**WEST YORKSHIRE
POLICE**

To: Nick Willock Investment & Regeneration Service Kirklees Council Civic Centre 3, Huddersfield, HD1 2EY	Ref: 2014/62/91813/W Date: 10 th July 2014
--	--

**Hoyle Ing Dyeworks, Manchester Road, Linthwaite, Huddersfield
Part demolition and conversion of mill to dwellings and erection of new dwellings**

Appendix C
Architects Plans

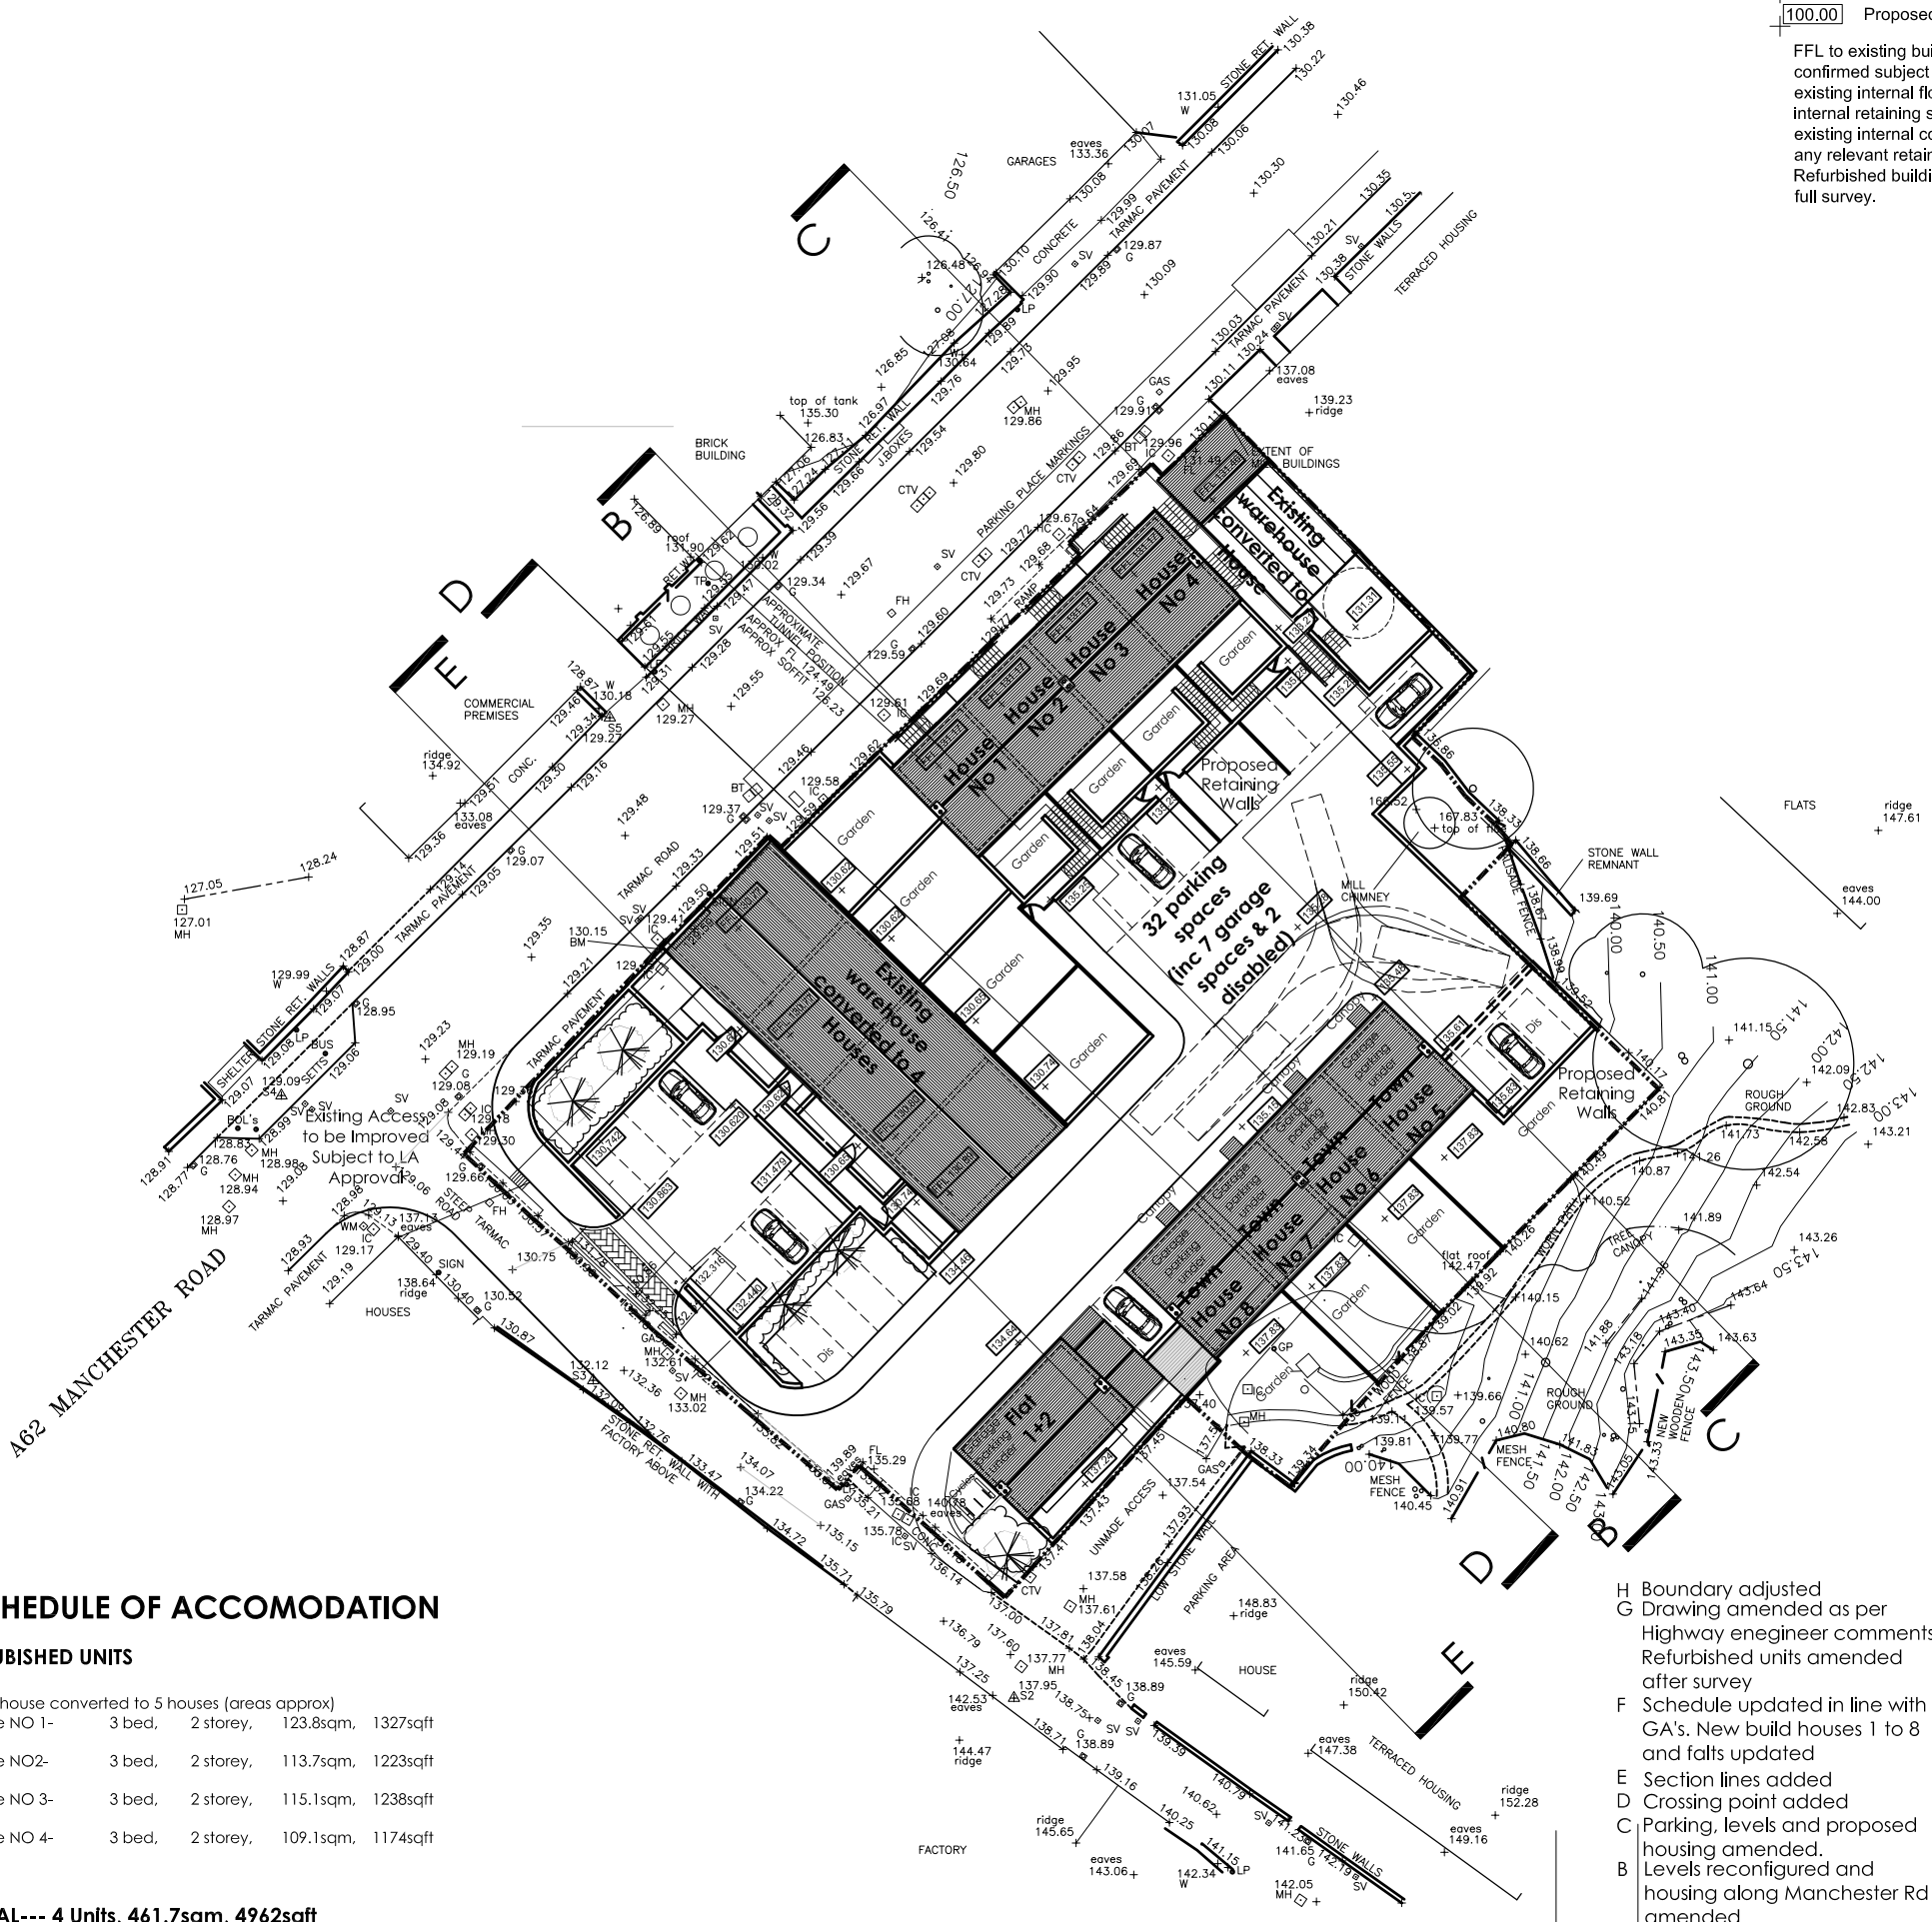
Rear of plots 13-17

This area is concern from a crime prevention point of view, and at present the police would oppose the layout as shown.

There is a secluded 'desire line' footpath (described on the drawings as a 'worn path') running in the wooded area at the rear of plots 13-17.

The shared access footpath at the back of the plots would make things even worse for the residents. There is nothing to stop free movement along the path between 16 & 17.

The path would be hidden from view behind tall garden fencing, and create a hiding area from where burglary could be committed, nuisance and anti-social behaviour likely to take place, and the fear of crime would be heightened amongst residents.

An alternative layout is needed in respect of plots 13-17, and I would suggest the options include

- Reorientation of the houses
- Removal of the shared footpath
- Including recognised security specification for doors, windows and fencing
